**Re:** CAO23-008 Sub1 Review  
6020 94<sup>th</sup> Ave SE  
Mercer Island, WA 98040

**Subj.:** CAO23-008 Sub1 Review

The following information is our response to the correction notice dated 7/20/2023.

SHEET **A1.0**

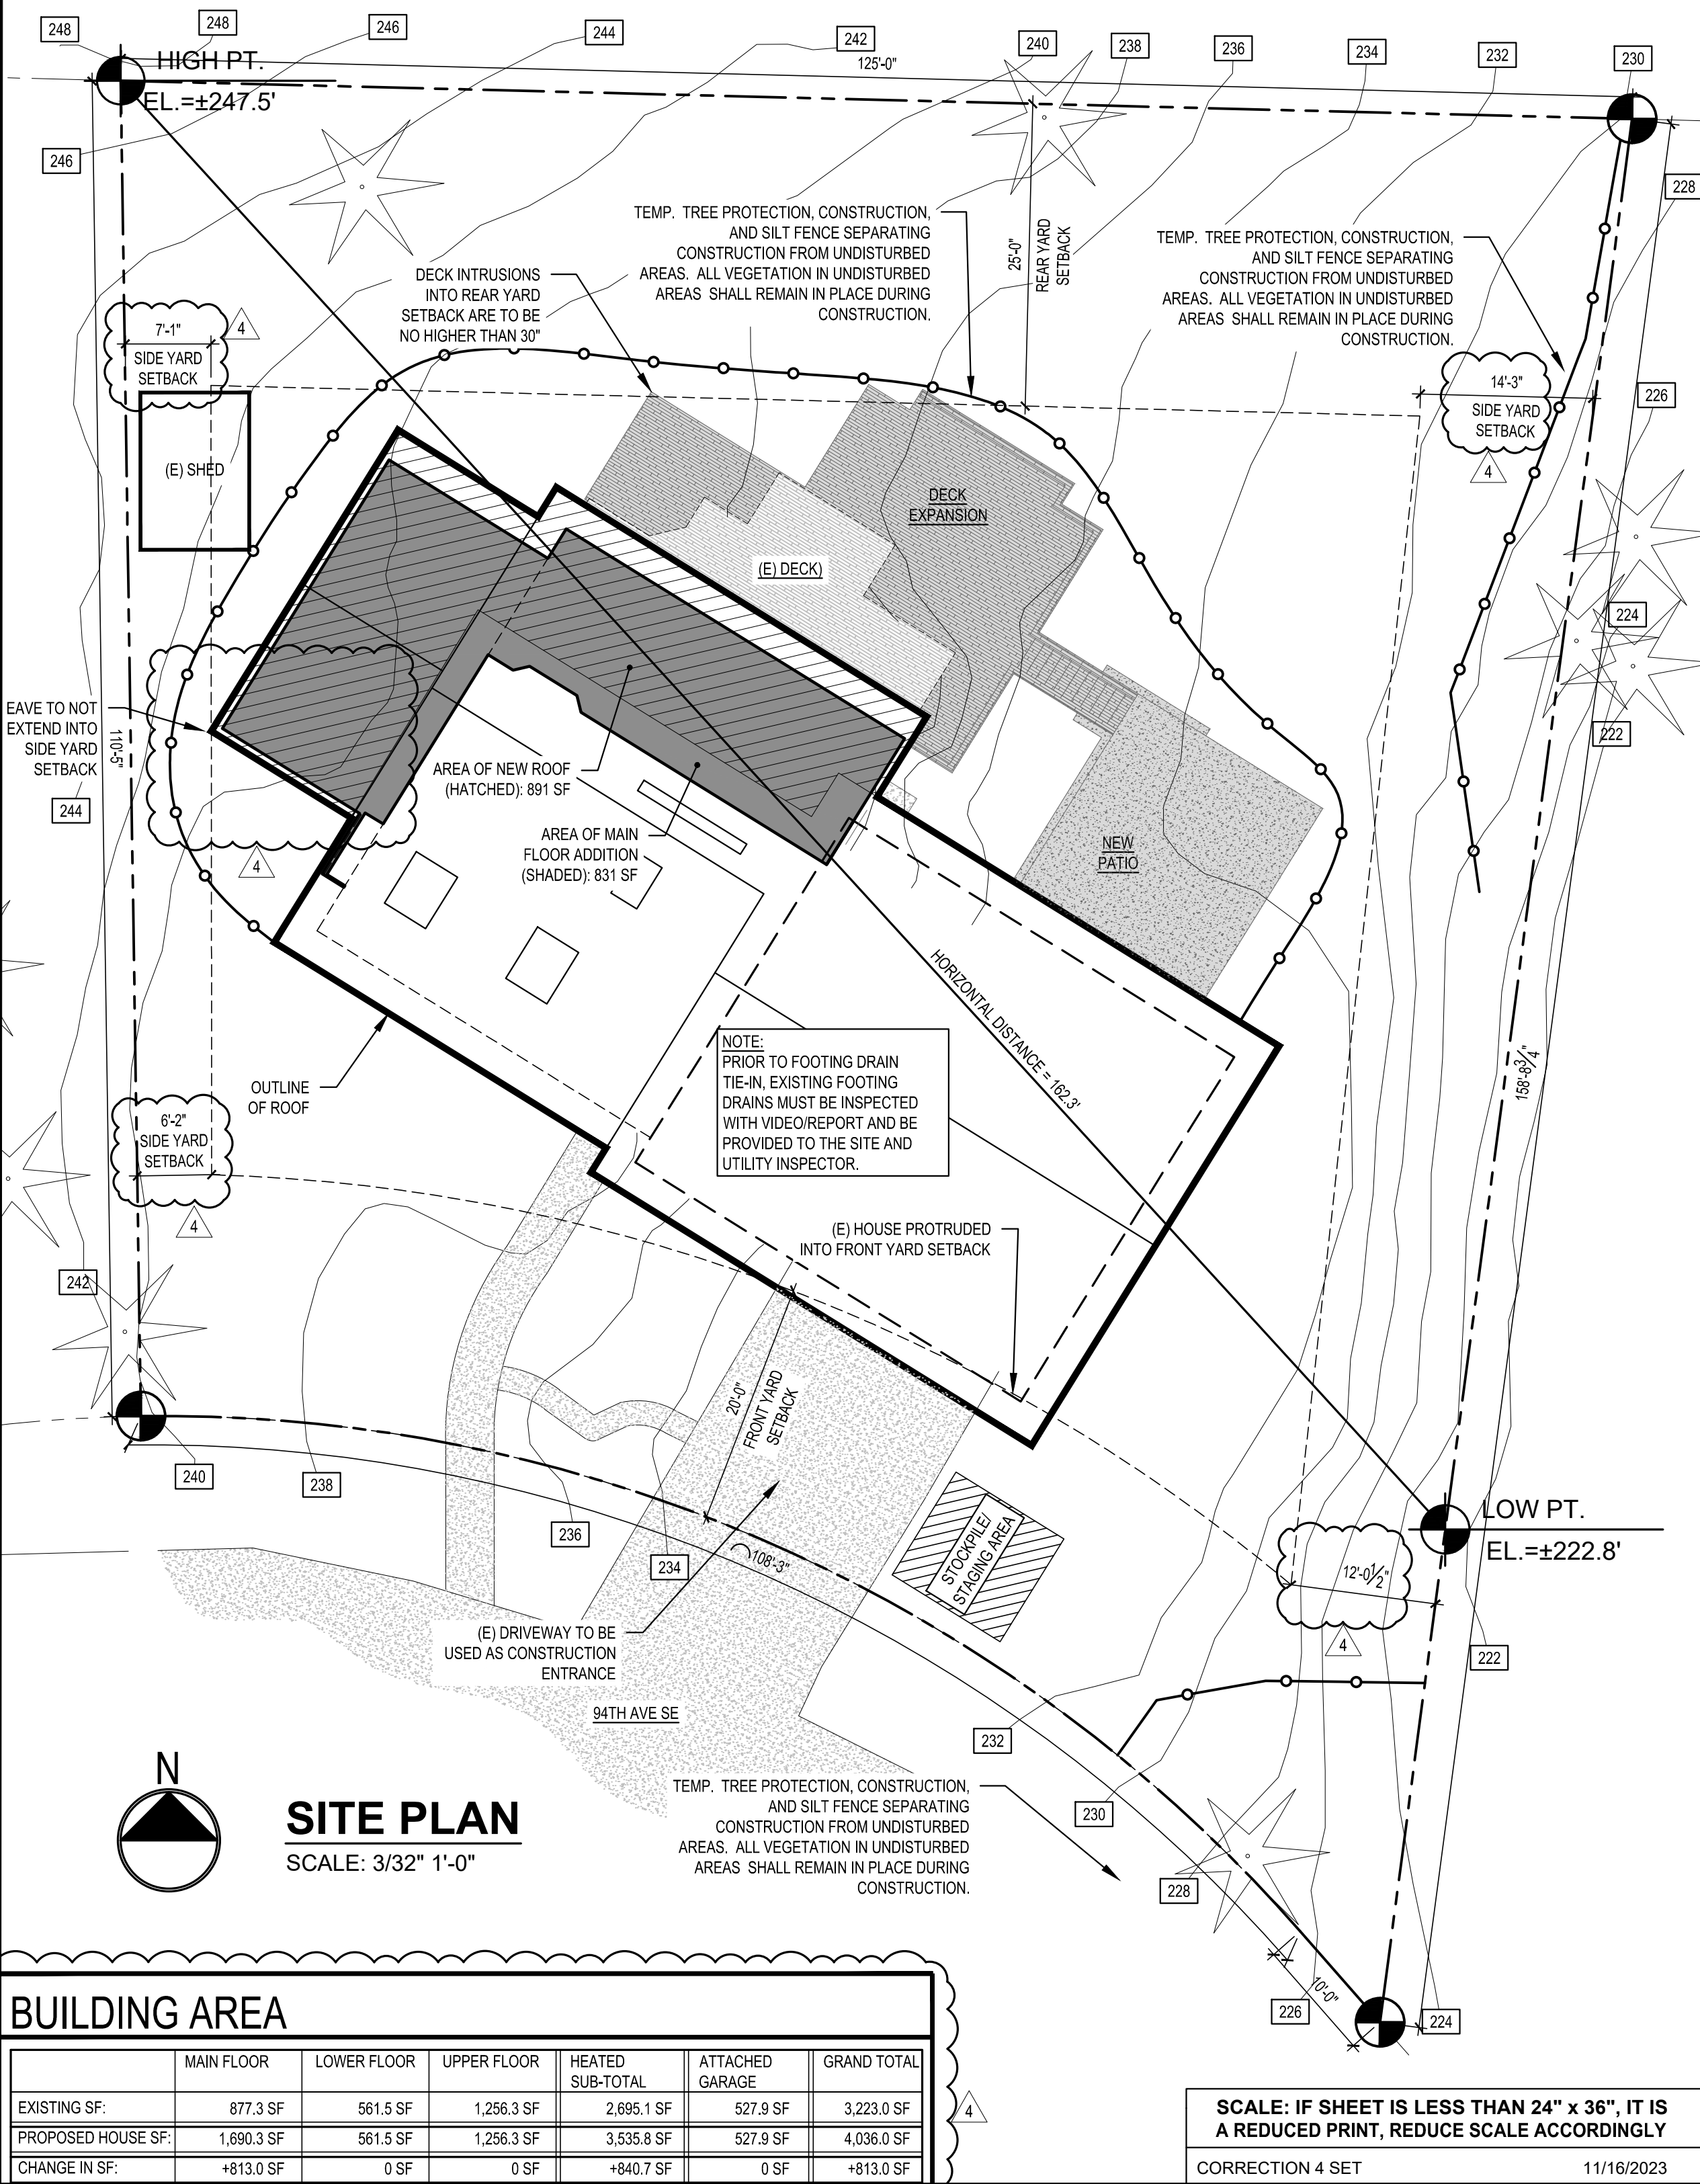
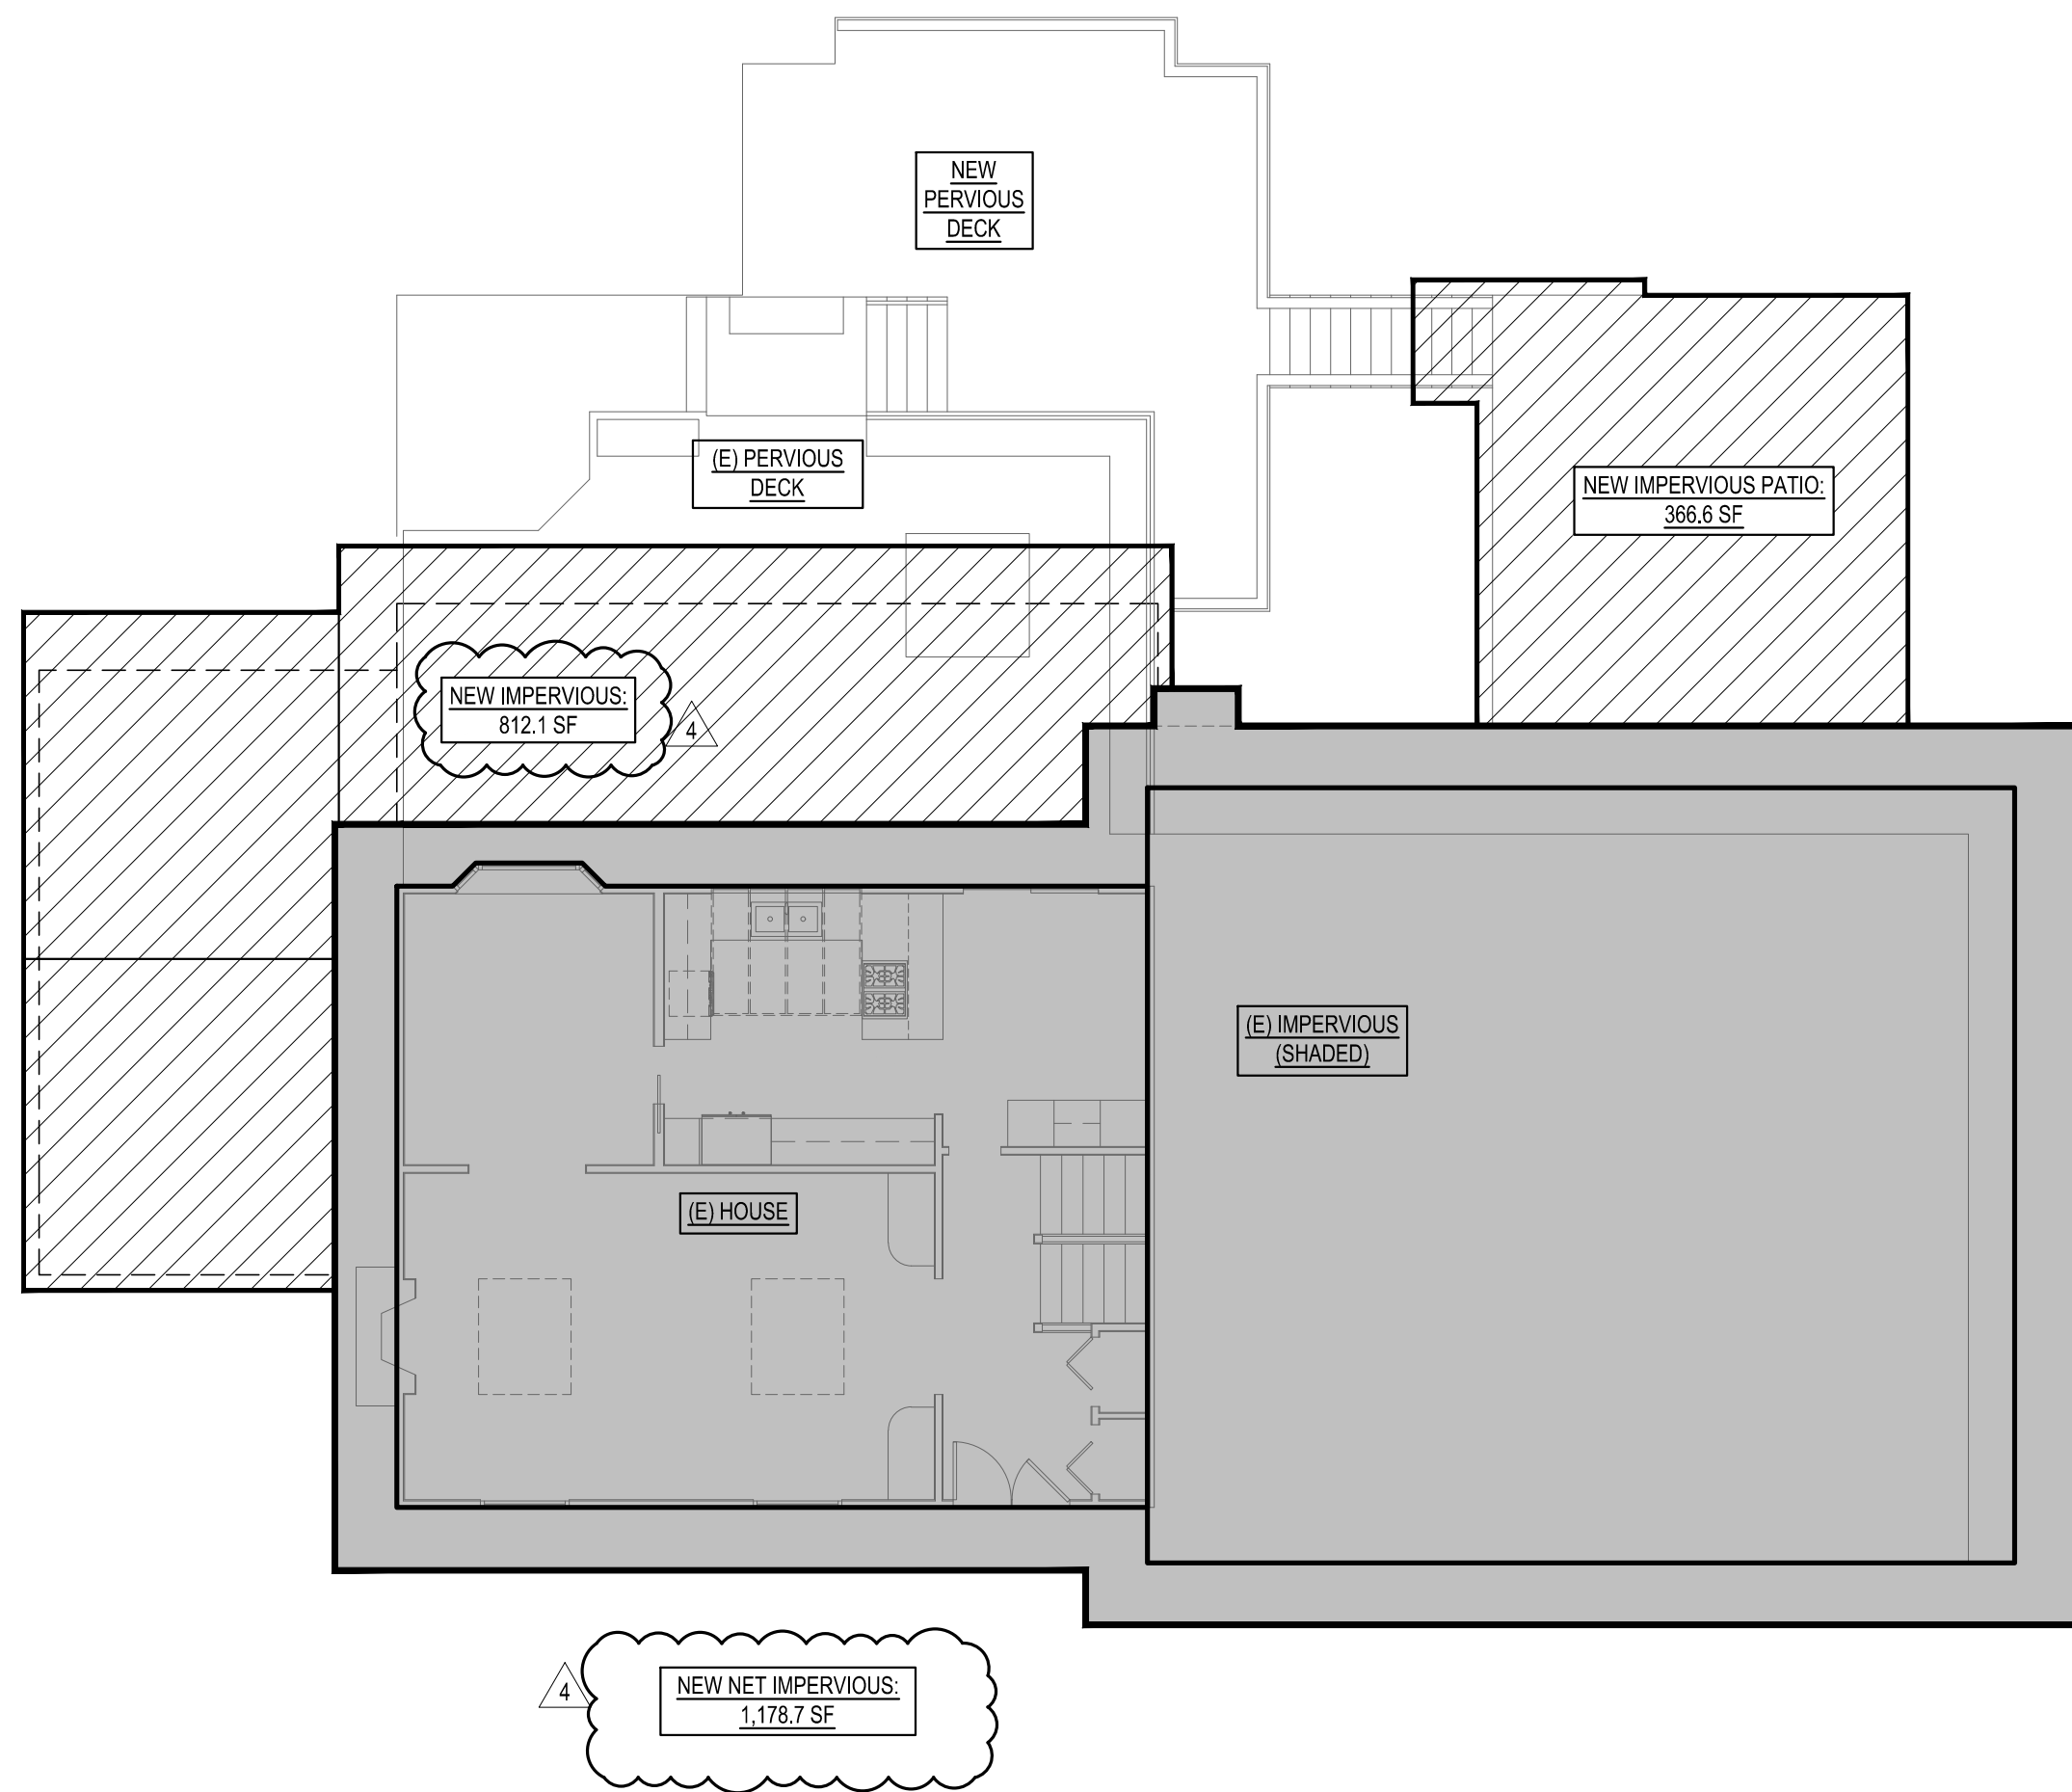
A1.0 *“Please upload new plan set to match building permit resubmission with new corrects.”*

**Comment: New updated planset provided that matches main permit corrections.**
